From: Anita Gardner <Anita.Gardner@arun.gov.uk>
Sent: 14 October 2020 10:40
To: Planning.Responses <Planning.Responses@arun.gov.uk>
Subject: FW: M/63/20/PL 46 Sea Lane, Middleton

I have noticed that the submitted plans include changes to the first floor layout to create an additional bedroom which is not referred to in the description of the application I am seeking clarification as to whether the application will need to be re-advertised on this basis.

Drawing No.:	Rev:
20-189-21	B

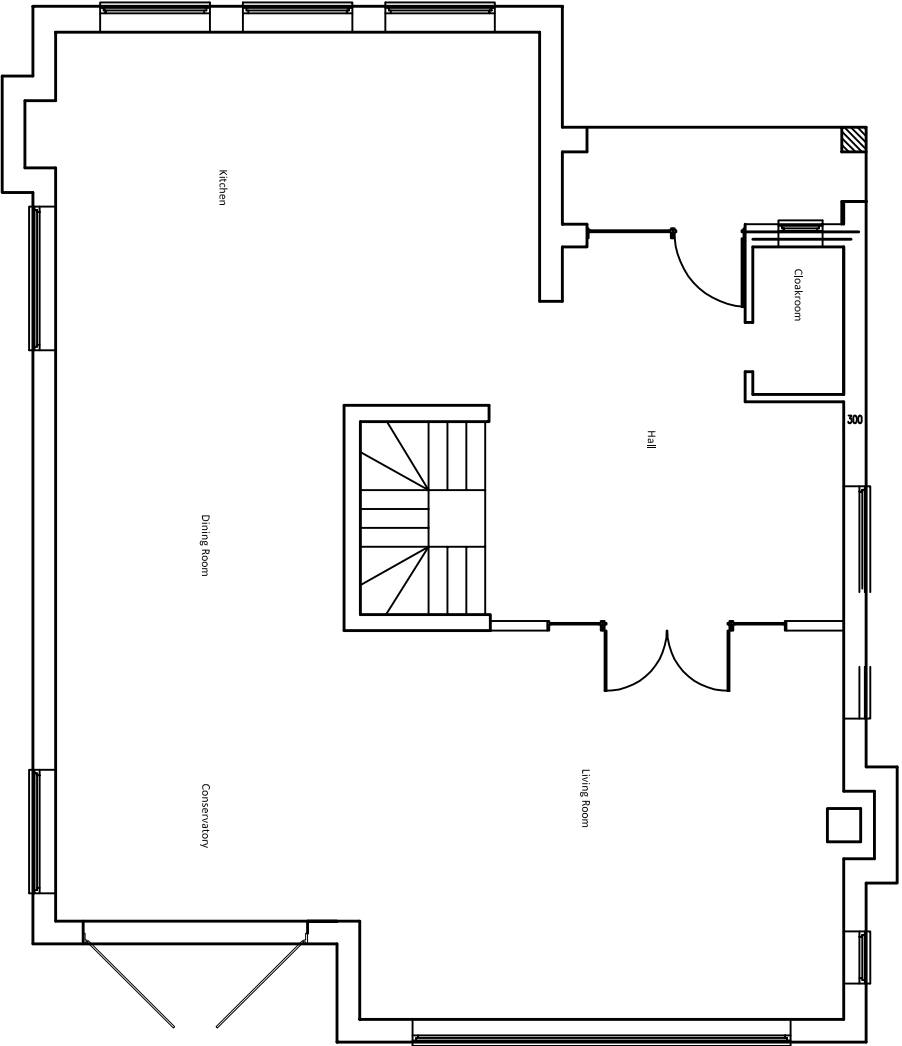
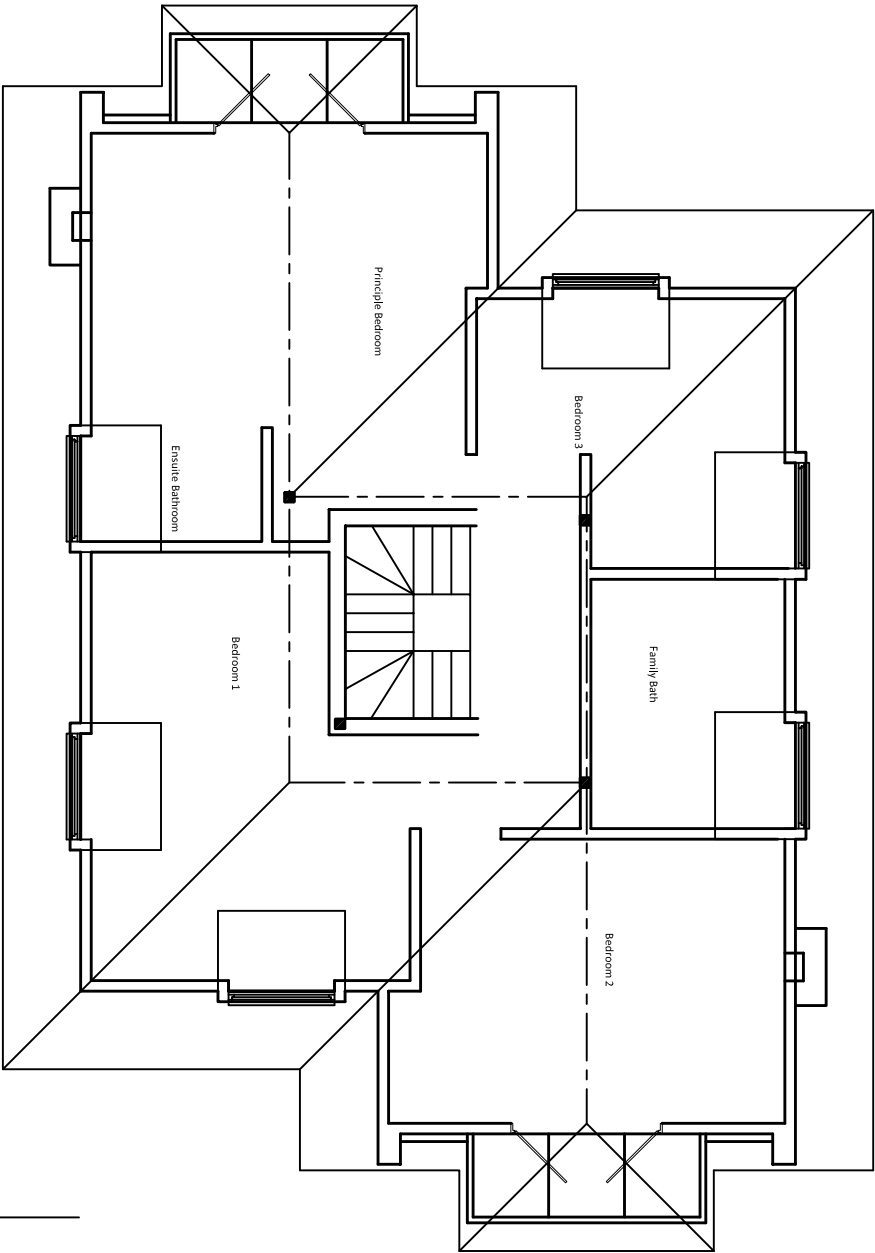
Whilst I do this can you confirm the gross internal floor area of the dwelling, the gross internal floor area of the proposed new bedroom, whether any additional parking provision is proposed and which of the approved plan numbers you are seeking to substitute with the proposed revisions. Having looked at the approved plans I believe that a revised roof and block plan will be required as part of this proposal.

The gross internal floor area is 221 m².

Drawn by:	Date:	Scale:
GW	OCT-20	As stated
Drawing/Cad Ref. No.:	20-189	
Drawing No.:	20-189-BP	Rev:

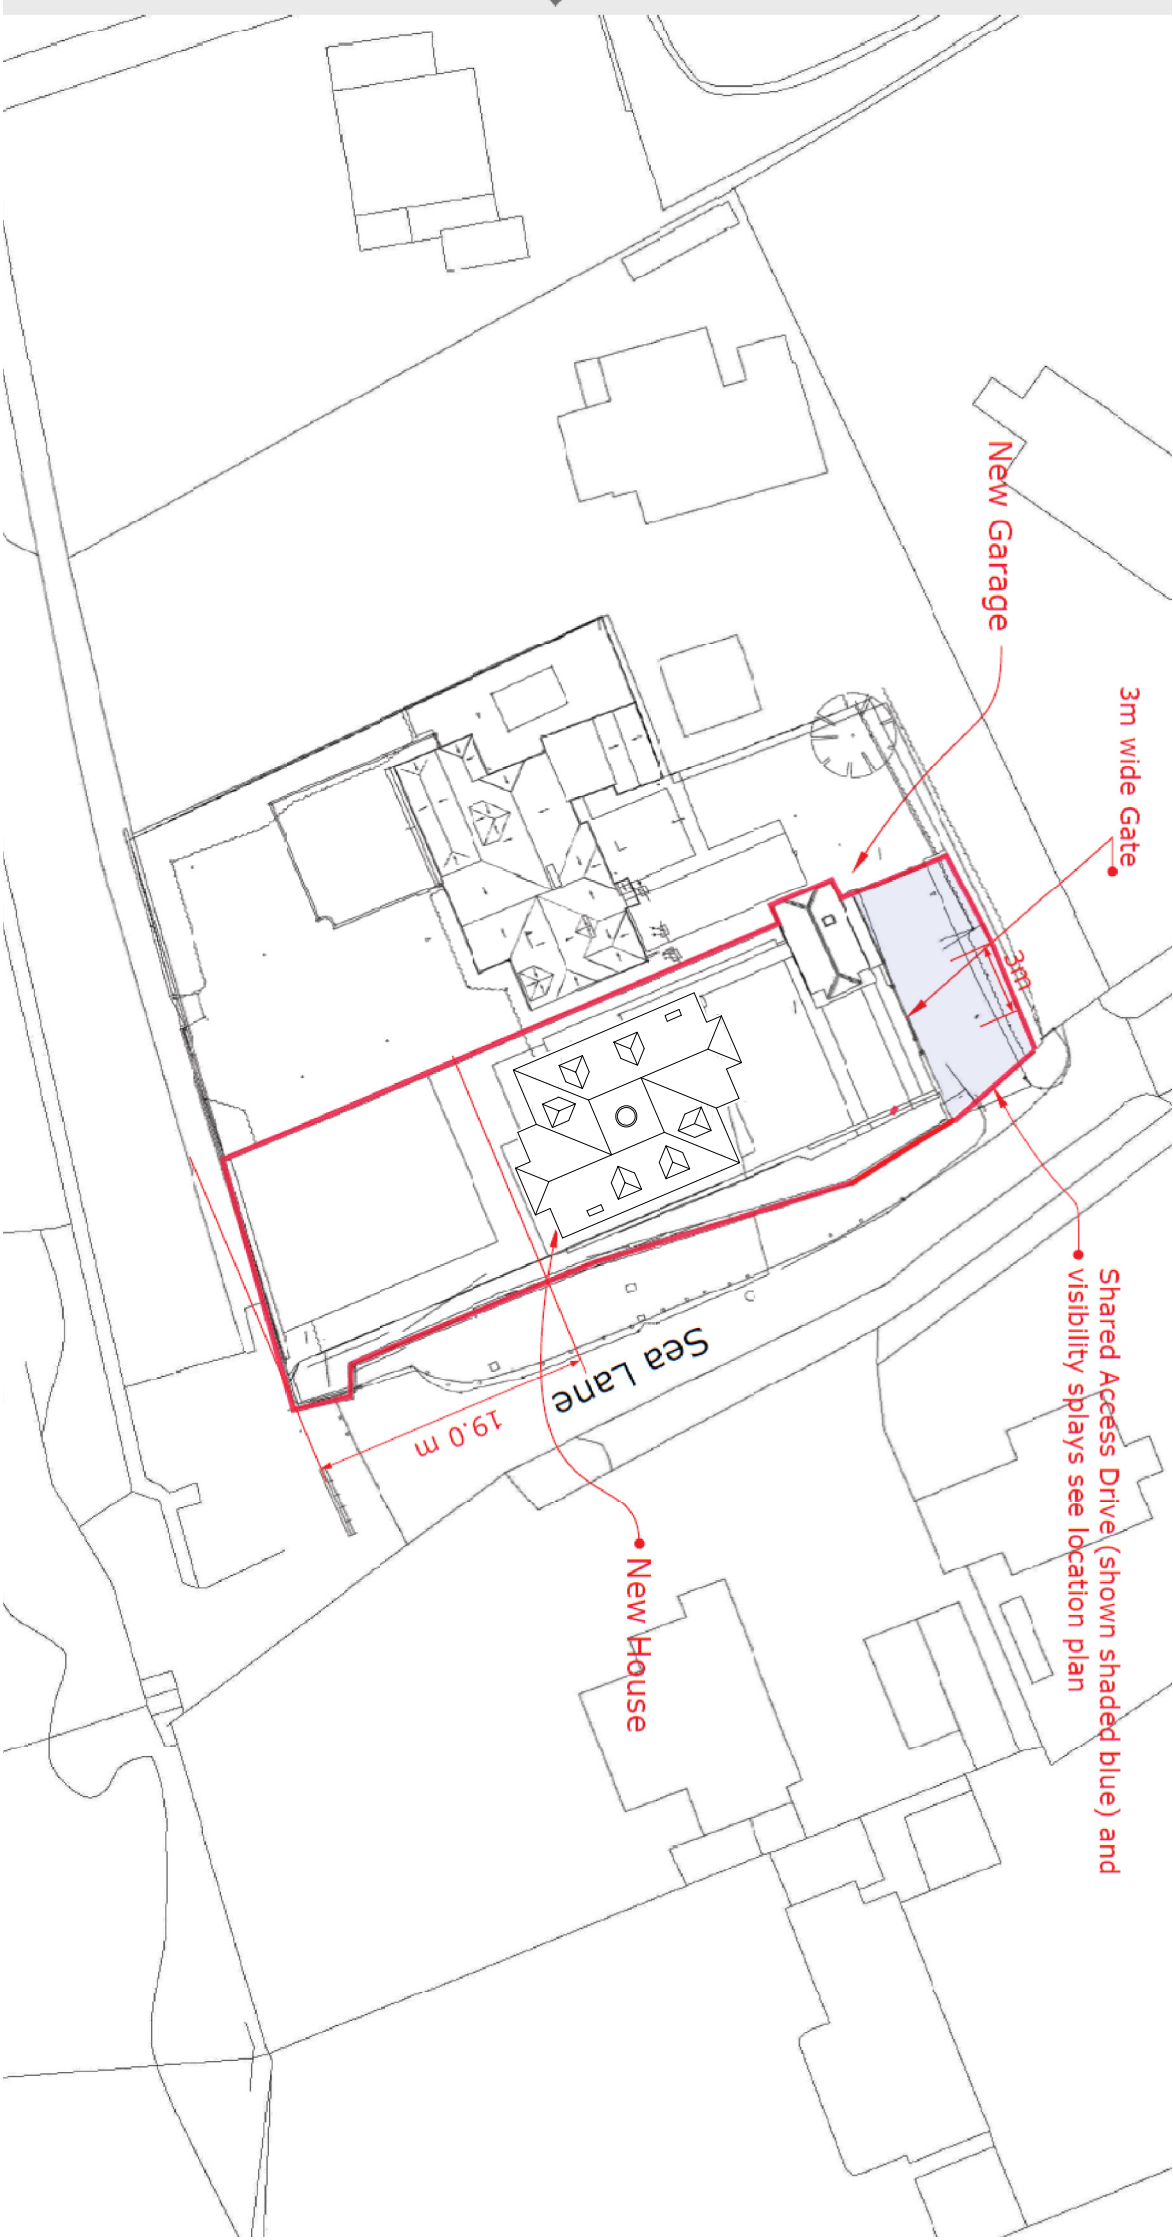
Can you also advise which of the original drawing numbers you are seeking to substitute and the gross internal floor area? With regard to car parking when Arun's parking standards are applied for parking Zone 2, which Middleton falls within, the parking requirements for a 3 bed and 4 bed dwelling increase by one space to 3 spaces. How many spaces were approved originally?

The original approval has 3 car parking spaces - this is to be maintained.

Please find attached a copy of the Roof Plan 20-189-202 and Block Plan drawing no. 20-189 BP with the appropriate amendments.
